KIRKLEES METROPOLITAN COUNCIL INVESTMENT & REGENERATION SERVICE

DELEGATED DECISION TO DETERMINE APPLICATIONS FOR CONSENT, AGREEMENT OR APPROVAL REQUIRED BY CONDITION

Reference No:	2023/44/90772/W
Site Address:	Land at, Penistone Road, Fenay Bridge, Huddersfield, HD8 0AW
Description:	Discharge of conditions 3 (CEMP), 7 (waste collection), 14 (soft landscaping), 17 (boundary treatments) and 25 (tree/shrub planting) of previous permission 2020/90725 for erection of 68 dwellings with associated access, parking and open space (revised plans)
Recommending Officer:	Nick Hirst

DECISION – Discharge of Conditions – Split Decision

Drawing No. 22/491/EST/EXT/001 | Revision: A

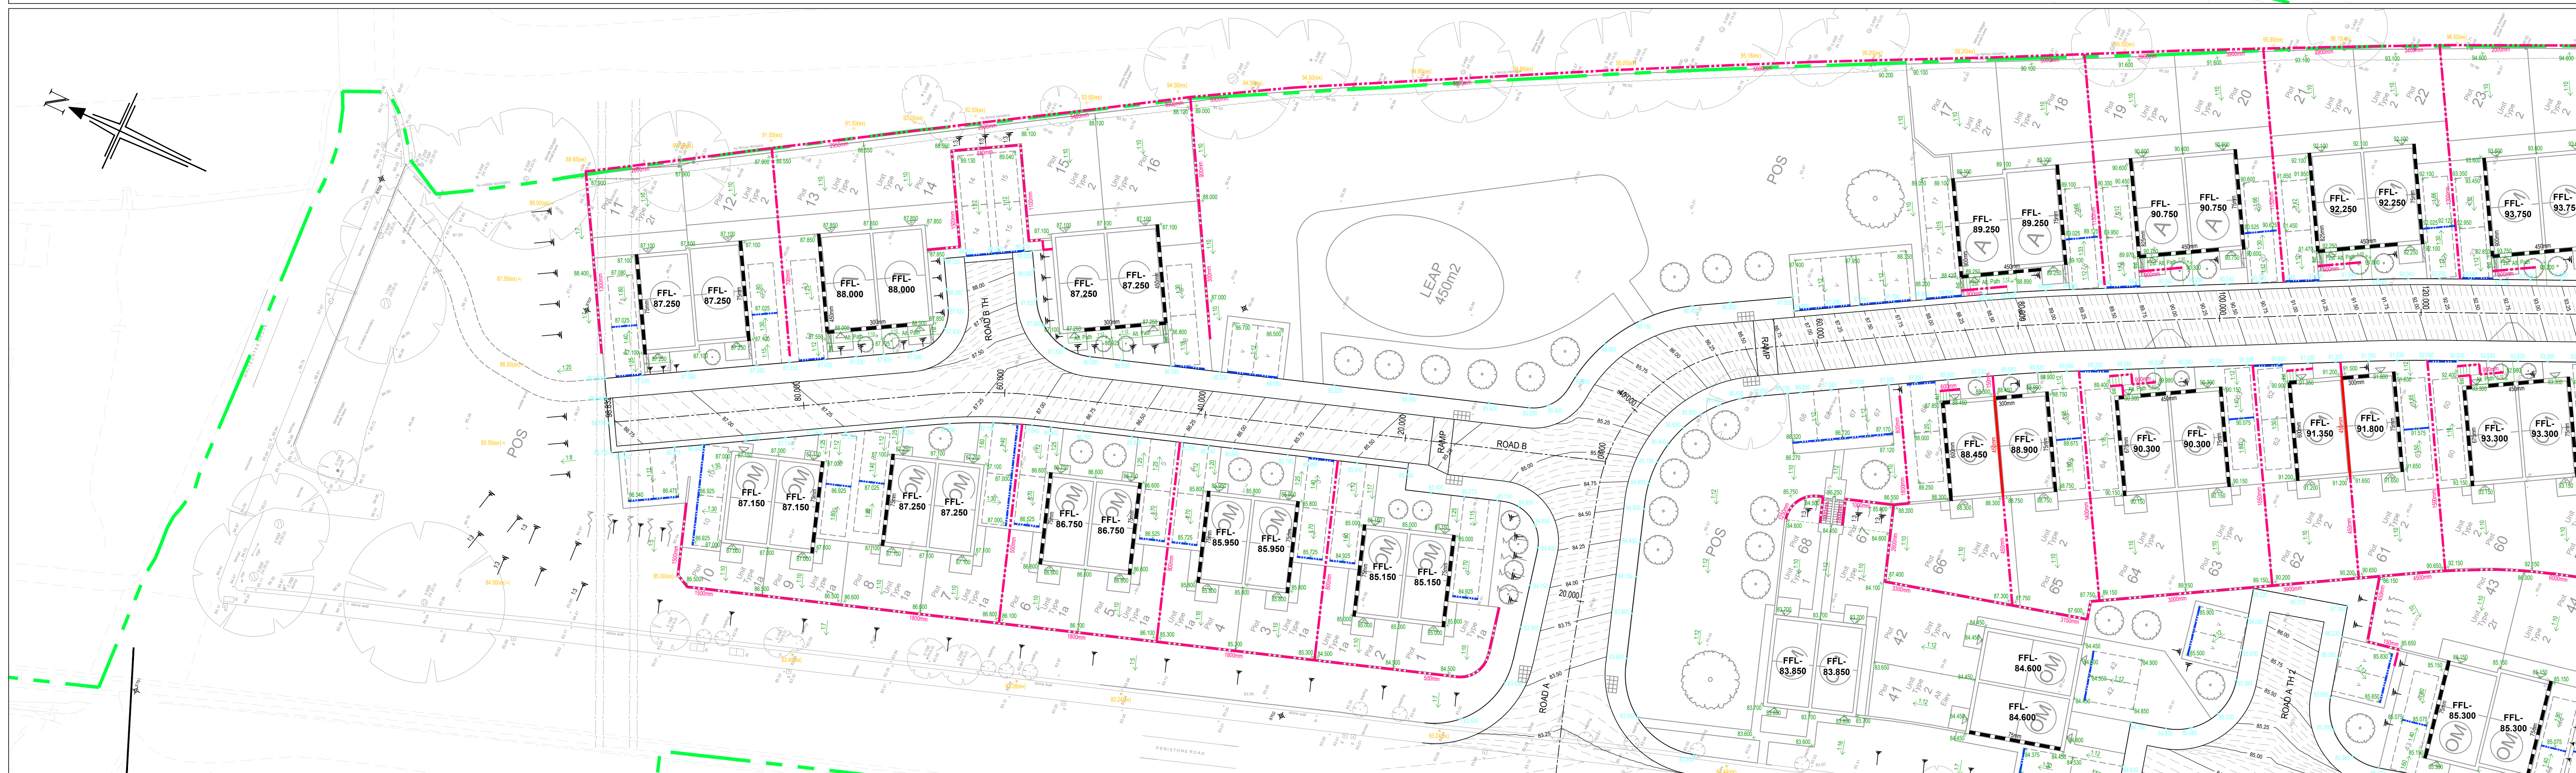
The plans do not show typical elevational appearances for one of the three types of traditional boundary treatment. Furthermore, the fourth boundary treatment is retaining walls, which have a dedicated plan. Within this plan several different types of retaining wall are proposed across the site, but again no typical elevations are provided (only written descriptions are provided). The submitted details are insufficient to assess the visual and residential impacts of the walling.

Additionally, the proposal includes extensive excavations near to a veteran oak. There are concerns over potential impacts upon the tree's health. No evidence has been submitted, such as an Arboricultural Impact Assessment, to demonstrate these works can be implemented without undue harm to the tree.

Finally, no details have been provided pursuant to requirement 17(a), preventing this being assessed and failing to comply with the condition. Condition 17(a) requires that the following be provided:

Drawing Title	
Construction Management Plan	
Site	
Penistone Road, Fenay Bridge	
Scale @ A1	Date
1:500	06.03.23
Drawn	Checked
BH	.
Drawing No.	Rev.
FB-006	B

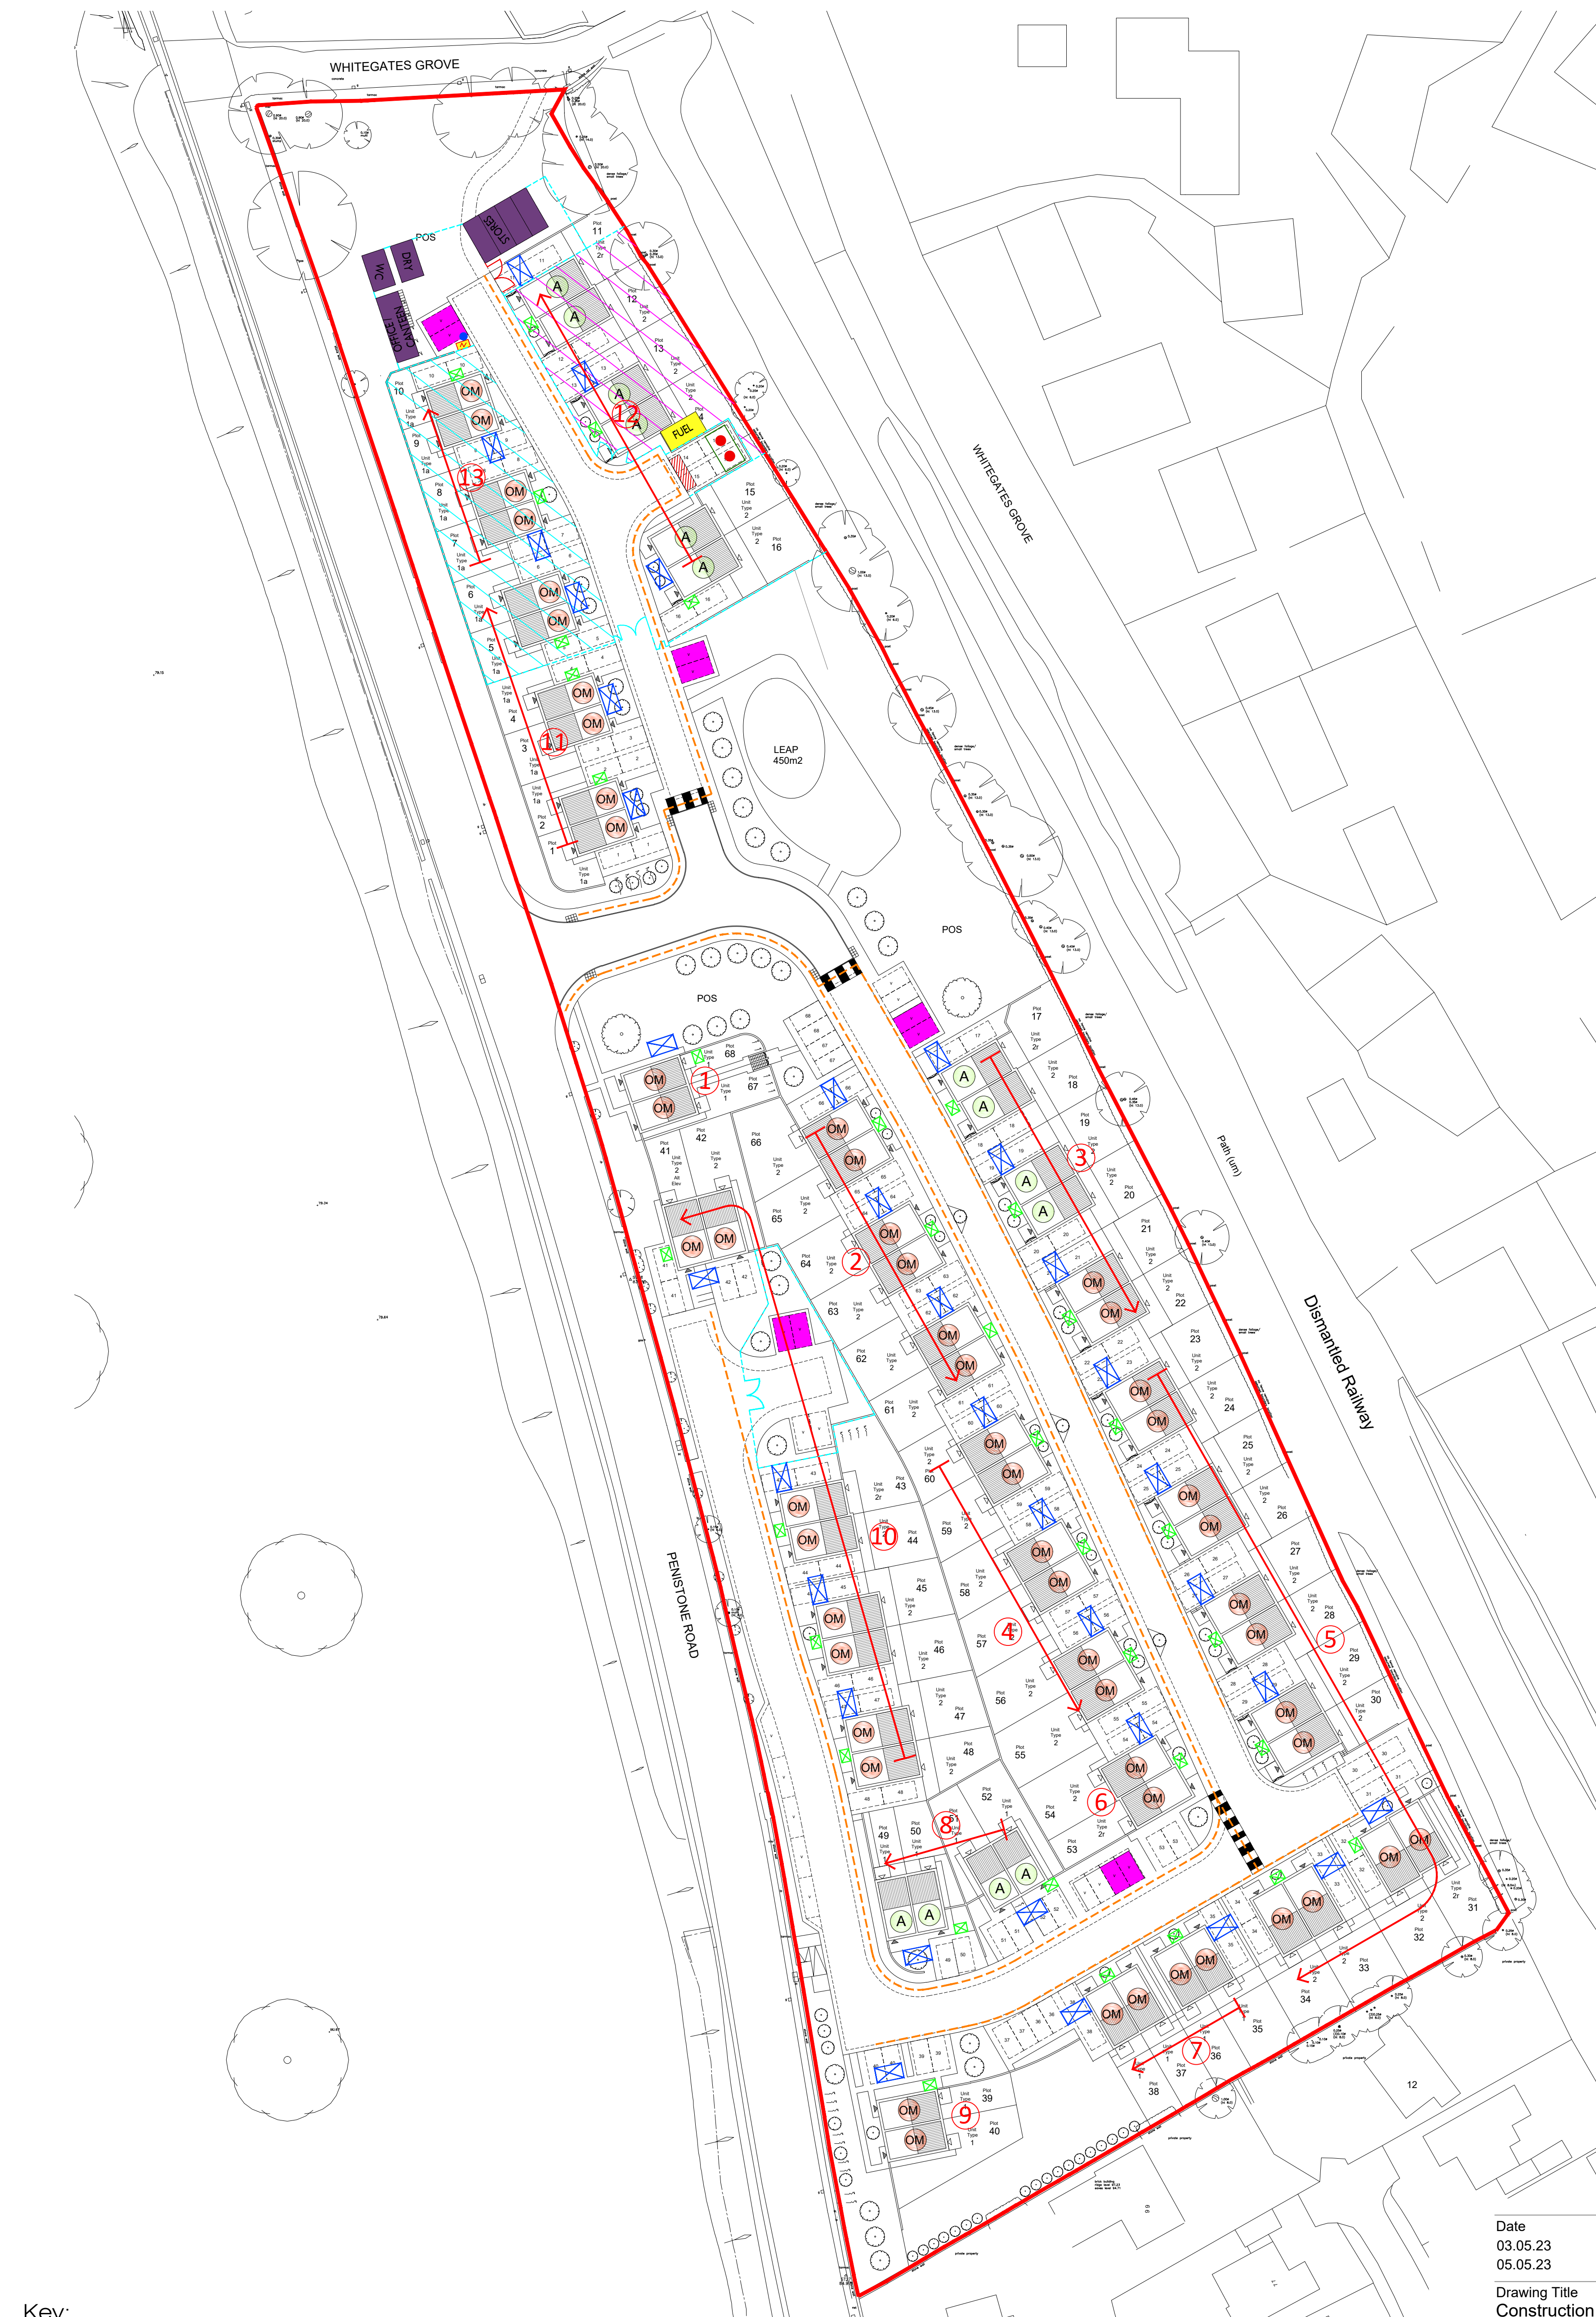
I can confirm that the submitted details are acceptable for the initial requirement of condition 7. However, be aware that condition 7 has the following ongoing requirement which must be adhered to, to ensure continued compliance with the condition:

Notwithstanding the above, K.C. Waste Strategy advise that continued discussions should be undertaken including a site meeting as works commence. This is in the interest of working collaboratively with the council's refuse collection service as the development progresses. To discuss this further please email waste.planning@kirklees.gov.uk.
